THE LONDON RESORT

The London Resort Development Consent Order

Appendix 11.4 Consultee Responses to the 2020 EIA Scoping Report

The London Resort ♦ EIA Scoping Opinion July 2020: reactions and responses

drawing title
Figure 12.56: Tree Constraints Plan Overview

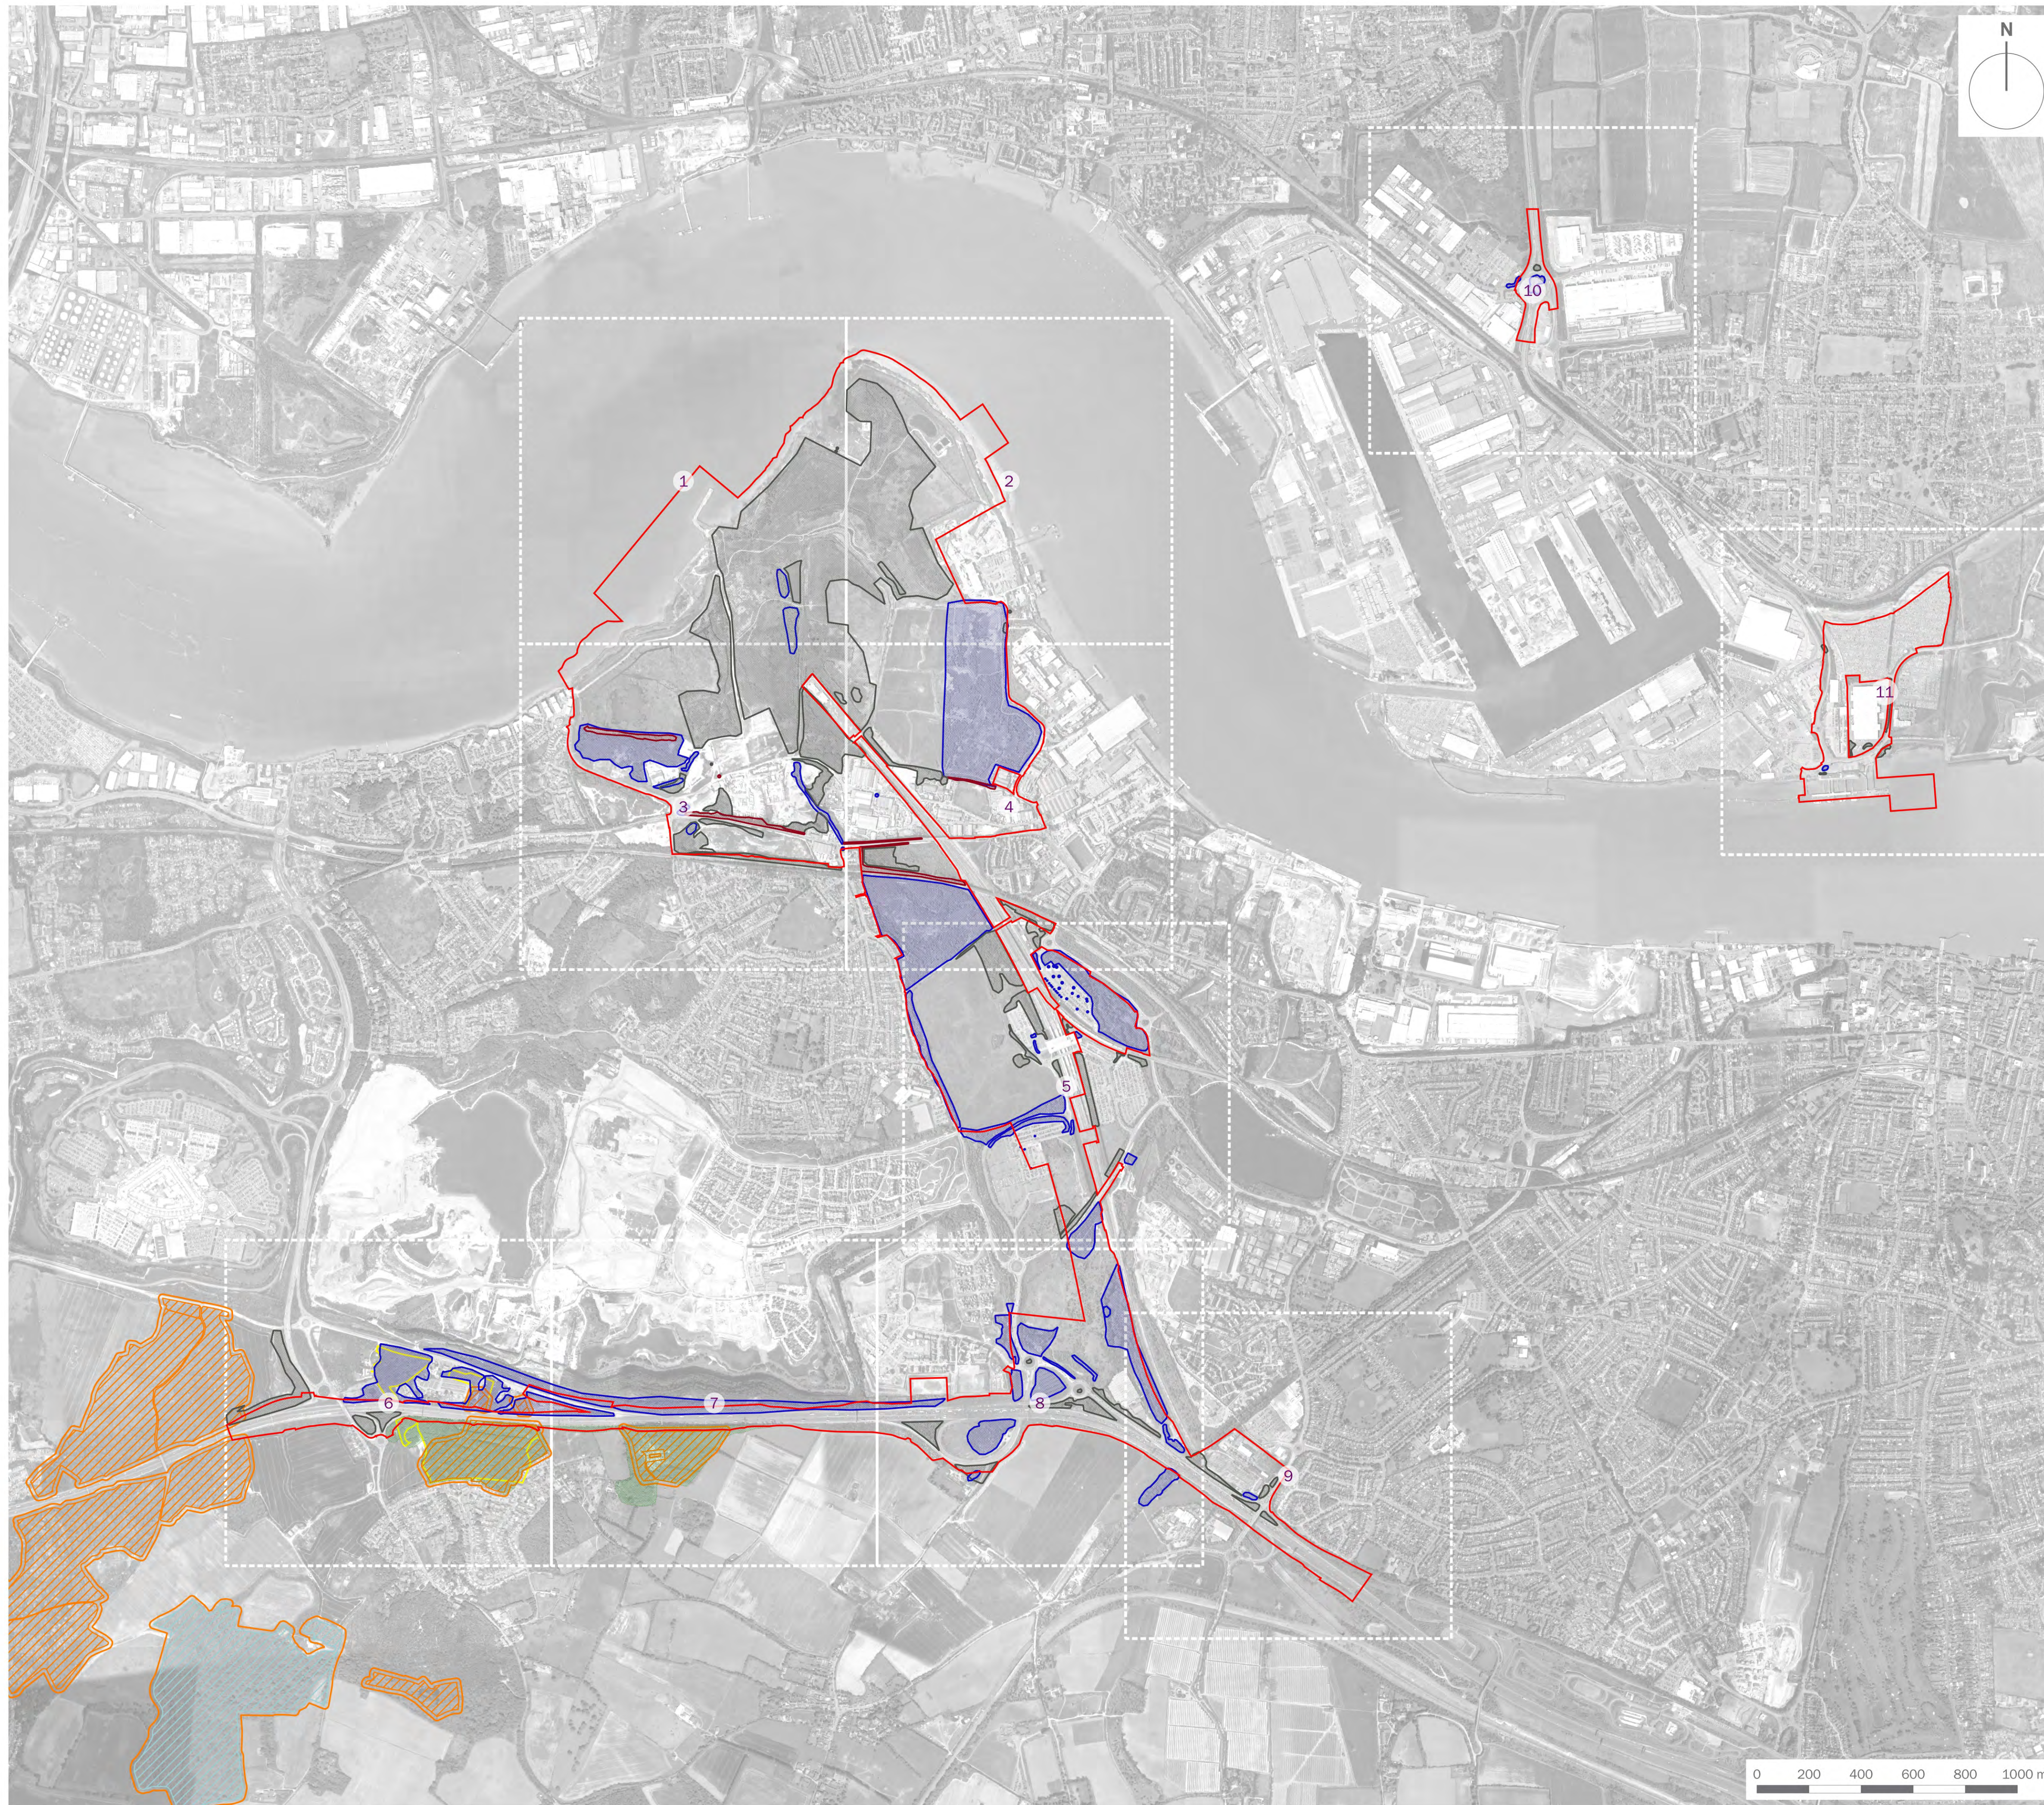
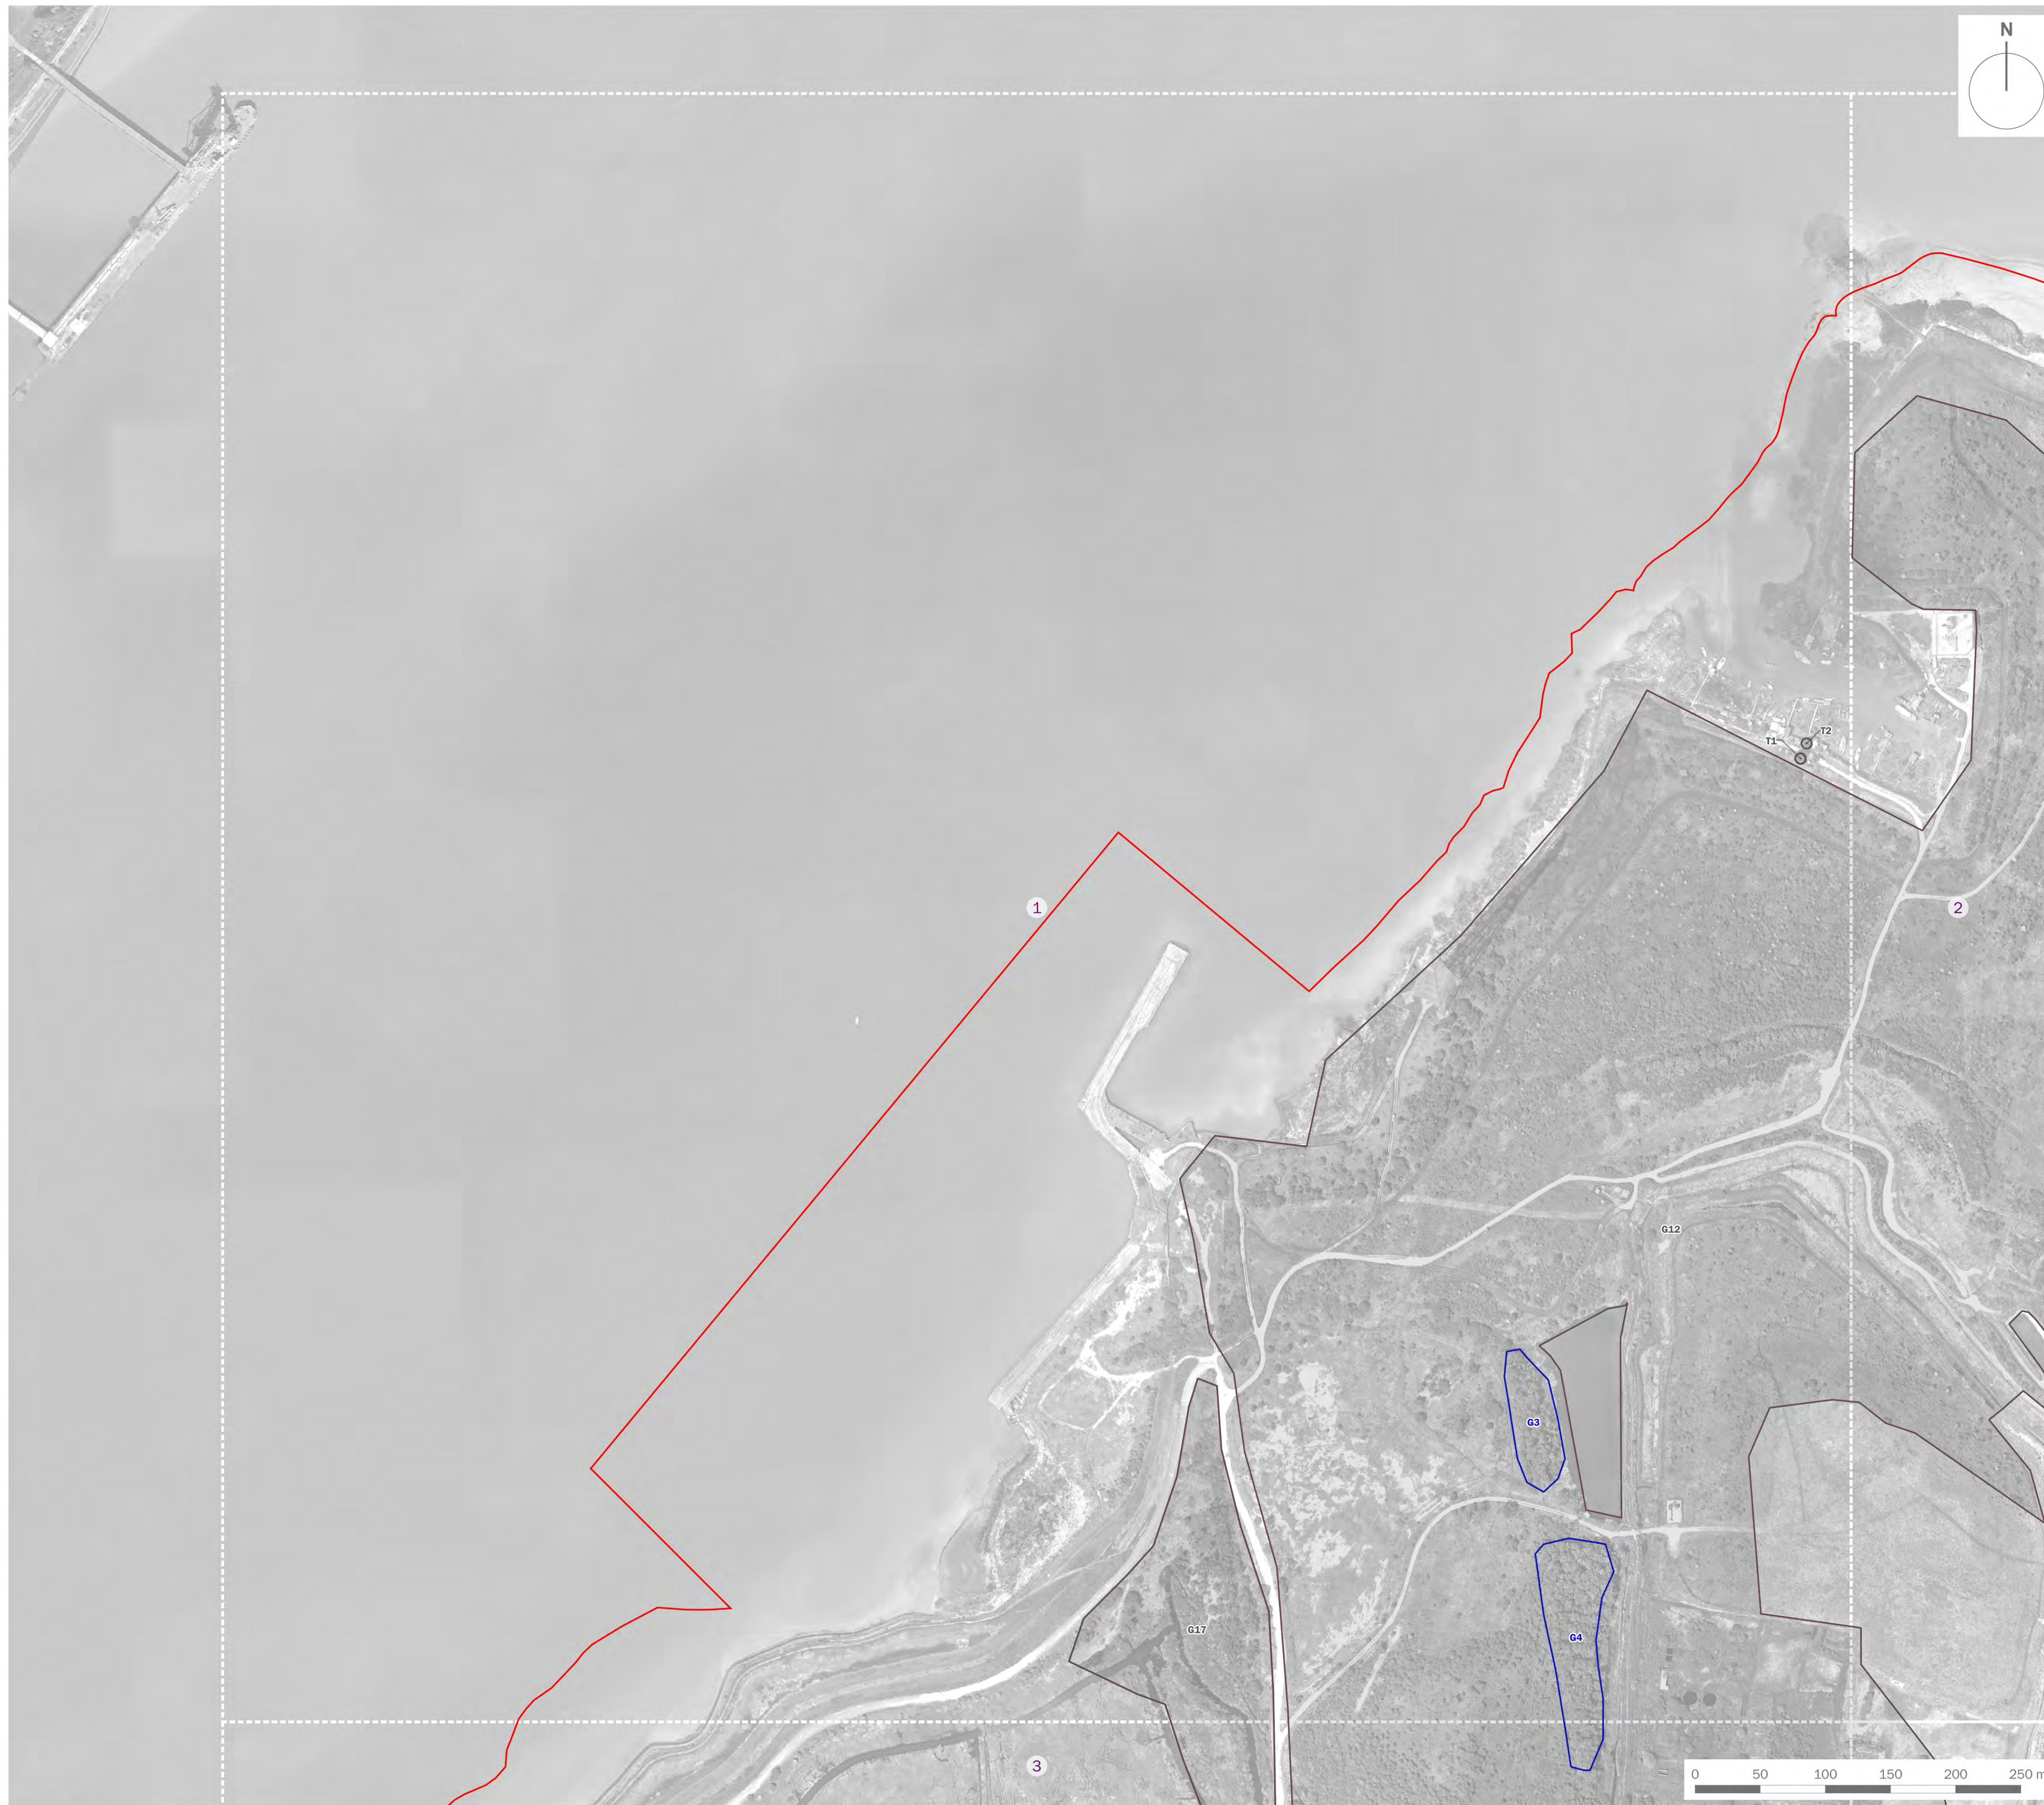
4.4.13/10.72	Tree Survey	The Scoping Report states that future assessment of landscape effects for London Resort will include a full tree survey and report, and an Arboricultural Impact Assessment appended to the Landscape and Visual Chapter of the ES. The Inspectorate welcomes this, though the ES should explain how this information has been used to inform the assessment of landscape receptor value (e.g. Ancient Woodland). The ES should also cross-refer to the assessment of ecological impact.	An Arboricultural Impact Assessment is contained at Appendix 12.9 (Document Reference 6.2.11.9).
